Re: Comment Response Letter for Application SD-2021-00034 Final Plat (DHO)

Enclosed for your review is a copy of the Tract 17, Bulk Land Plat Tracts 1 thru 18 Artiste Plat. The revisions are based on comments received in your letter dated, 02/08/2023. Below is a brief description of how the comments were addressed:

CONCEPTUAL UTILITY PLAN			
MDS CITY CENTER			
DRAWN BY:	AO	DATE:	11/11/2021
CHECKED BY:	MJB	BHI PROJECT NO.	20220088
		SHEET NO.	1 OF 1

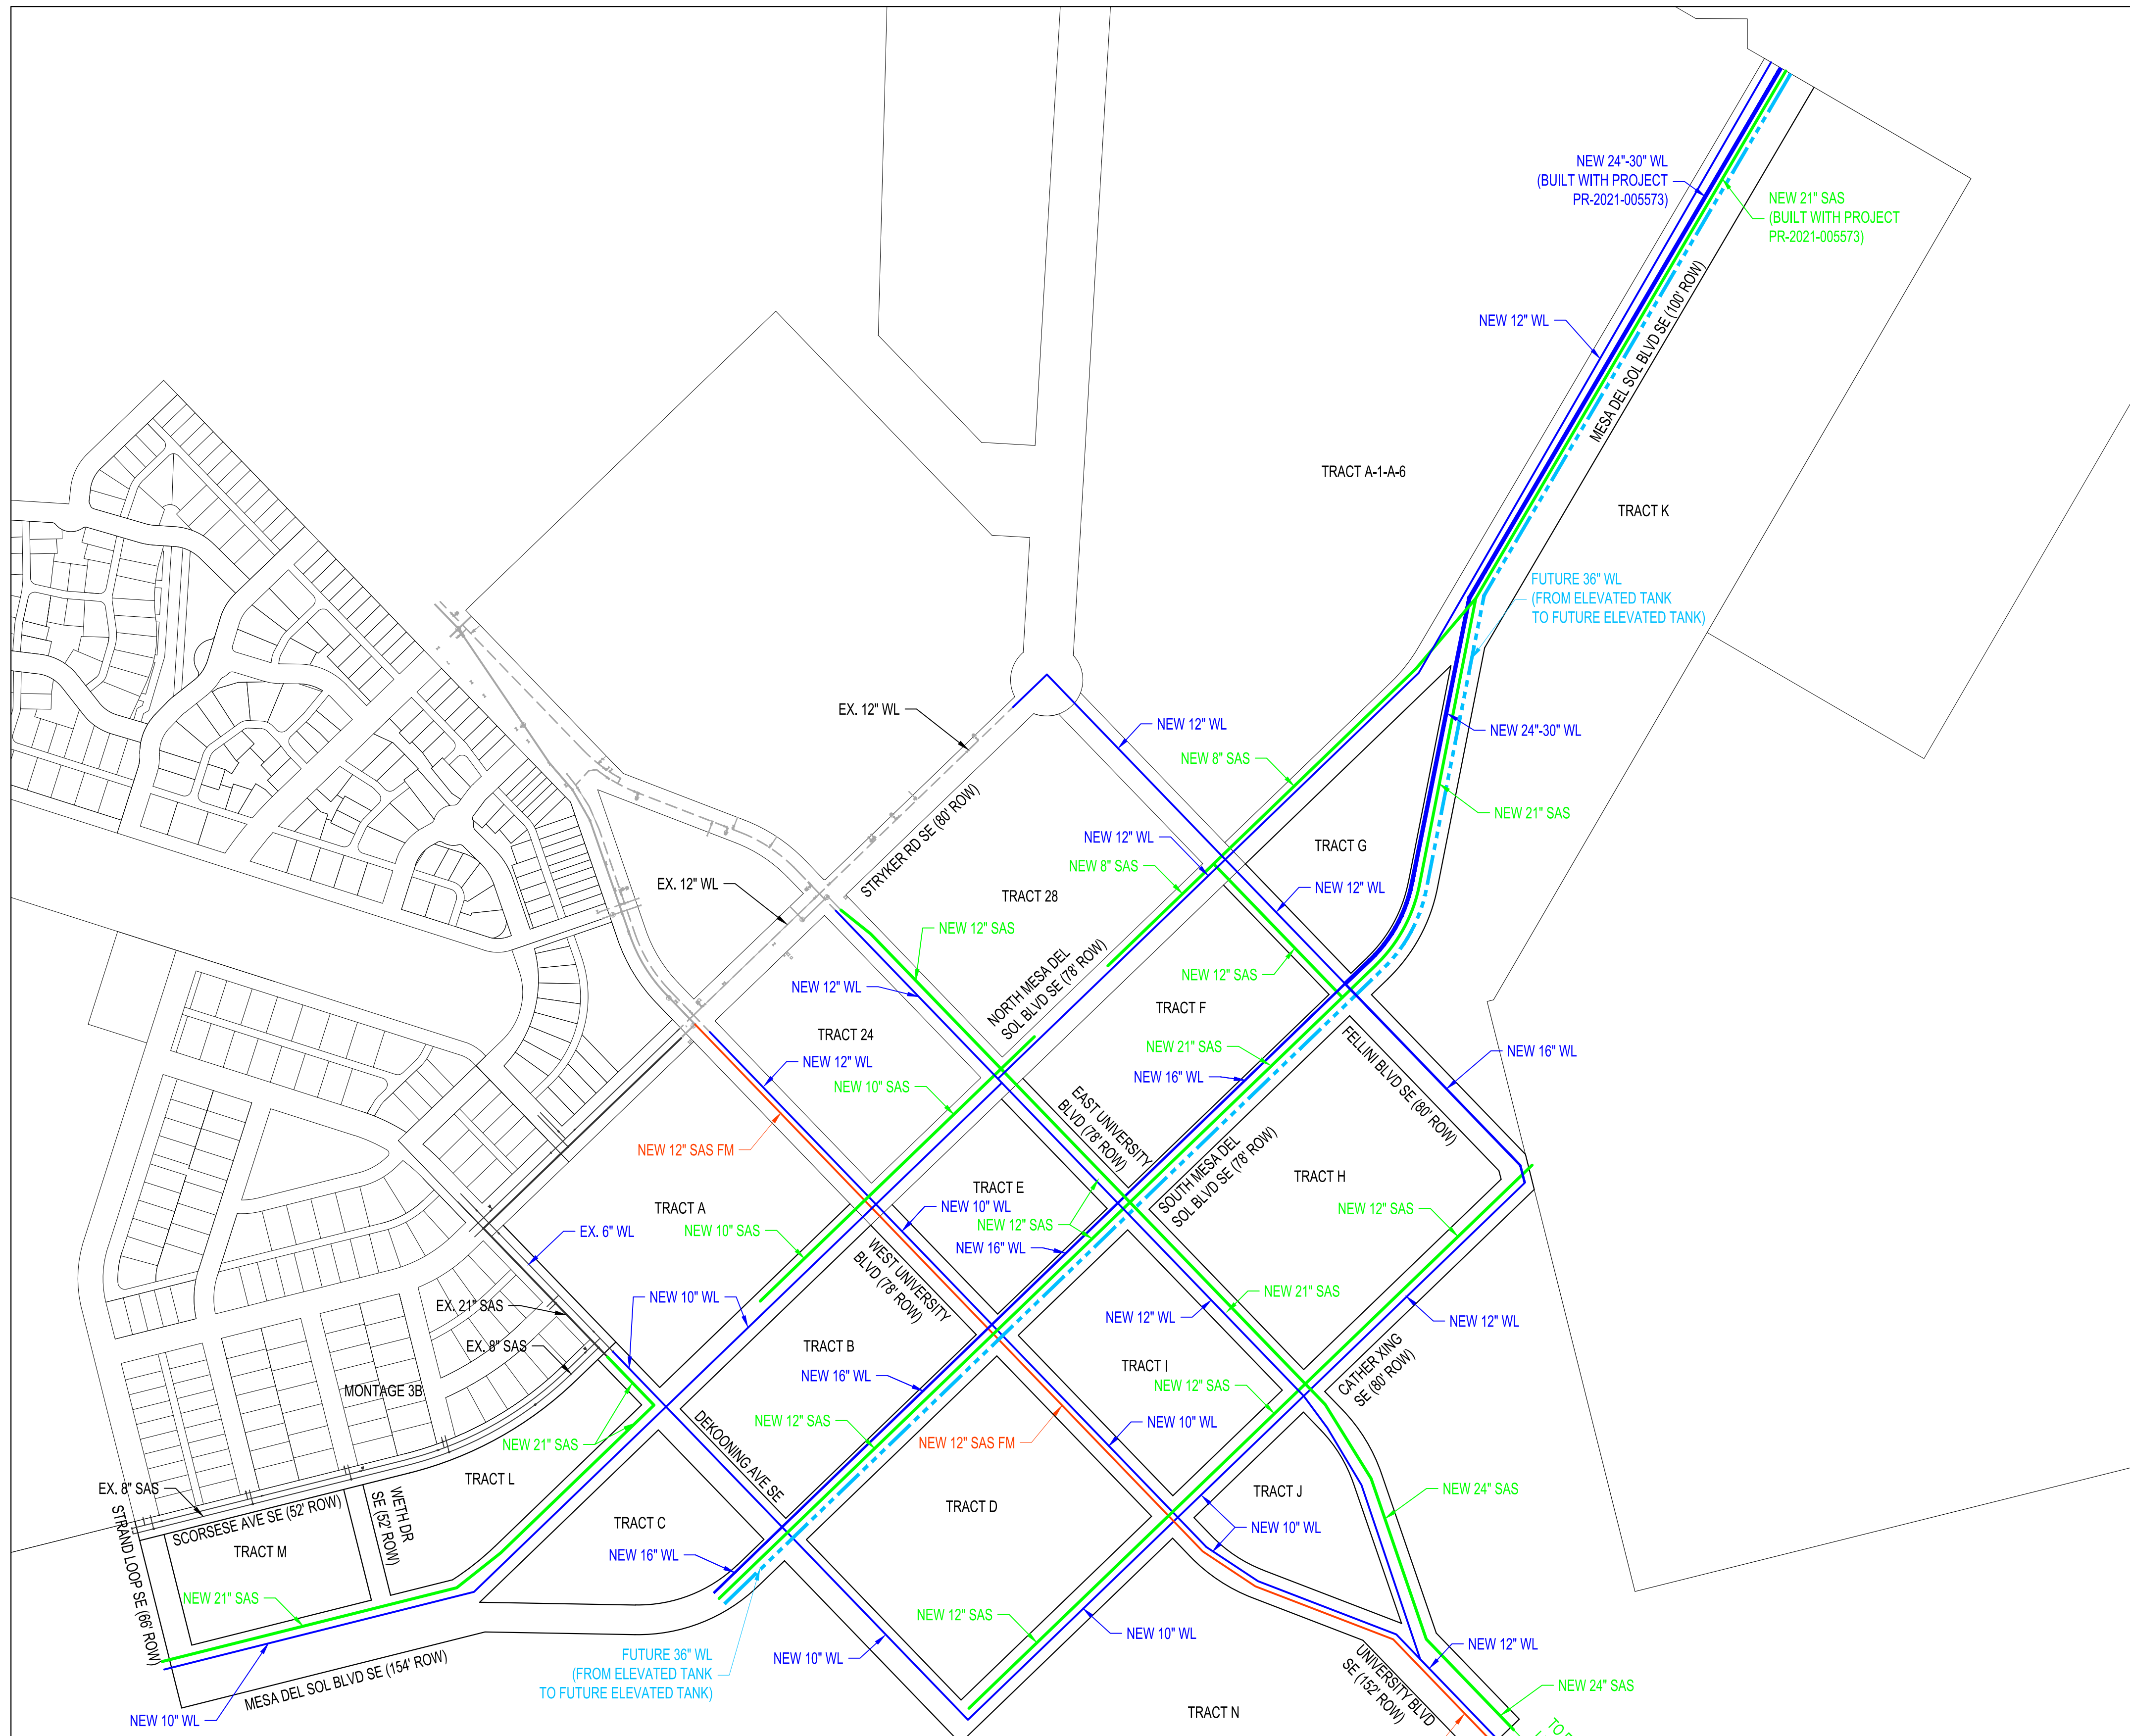
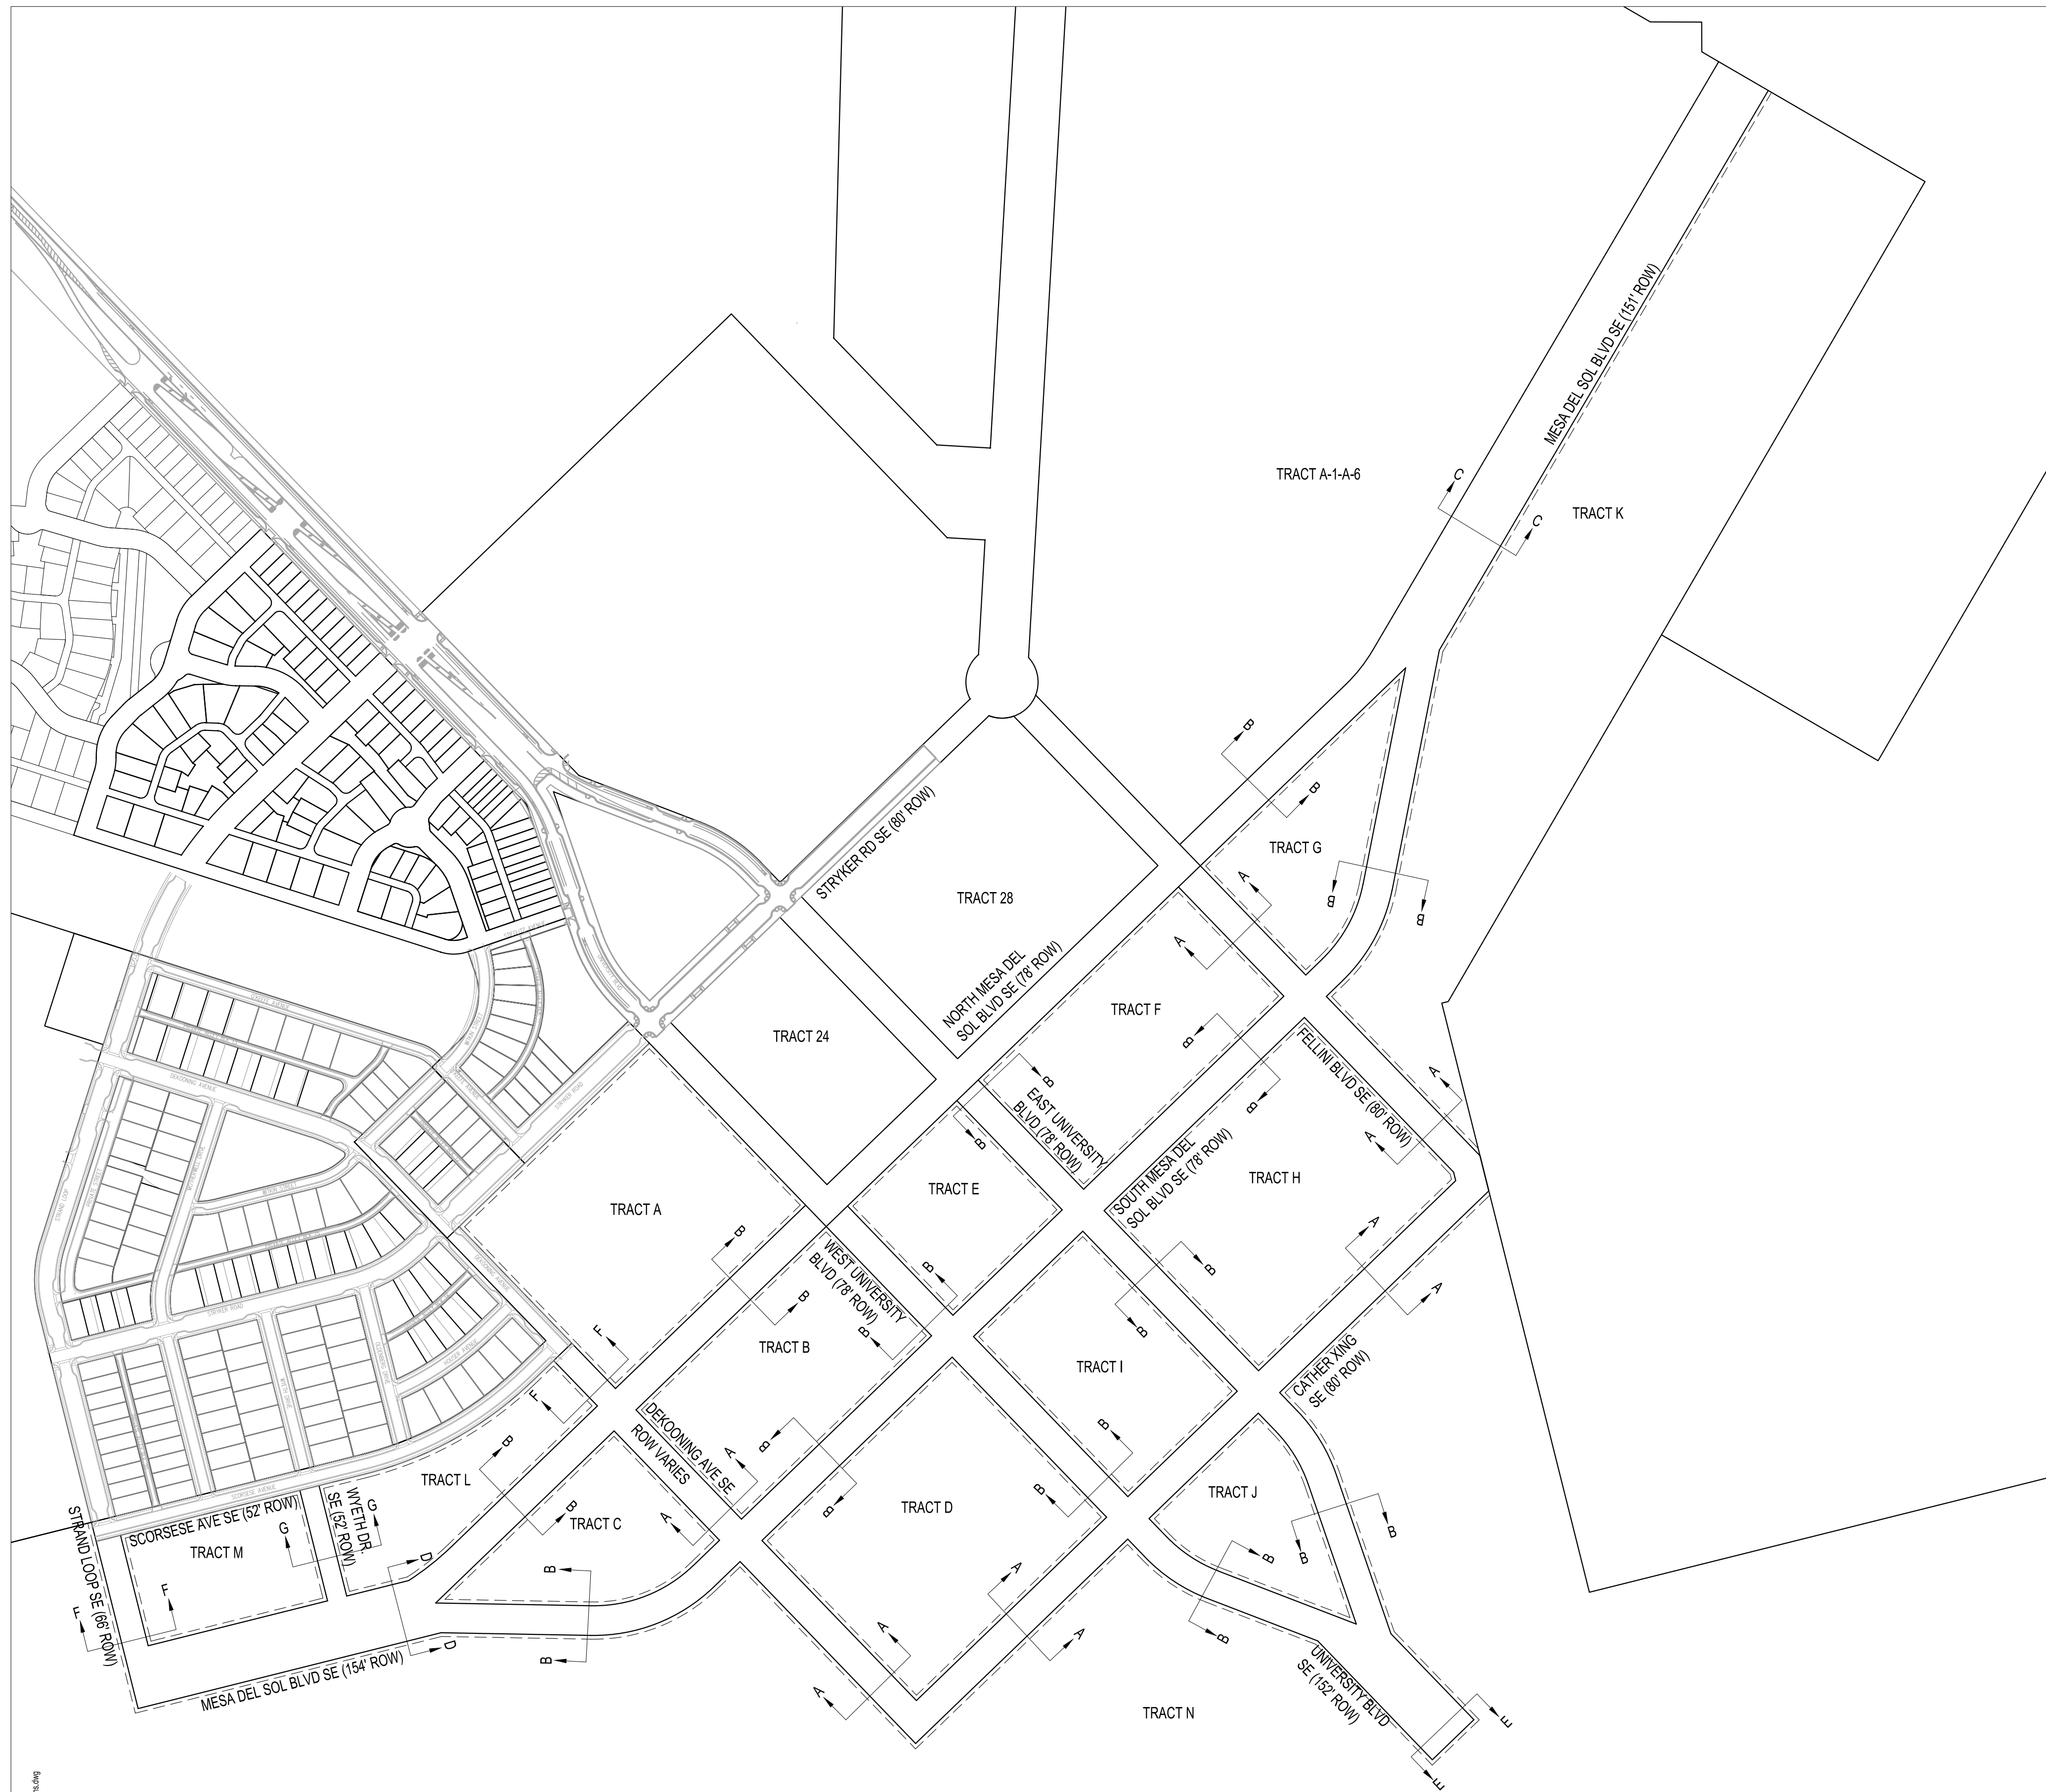
1. No objections to the proposed plat however prior to signature the following items must be resolved.
 - a. Please provide a utility plan to verify the infrastructure list is accurate.

- i. The provided serviceability letter #211028 has been written to detail what is needed regarding the proposed plat but does not commit service to any of the proposed lots as not enough information was provided to determine infrastructure sizing.

- **Response – please see attached utility exhibit reflecting the current approved infrastructure list.**
 - ii. All distribution lines are to be guaranteed and listed as 12-inch lines as noted in the Serviceability Letter.

- **Response – where lines are silent in the current master plan and most recent study completed by Stantec, 12" waterlines were used.**
- b. Easement N calls out ABCWUA Roadway. Please clarify the use of the easement. Should it be public water and public sanitary sewer?
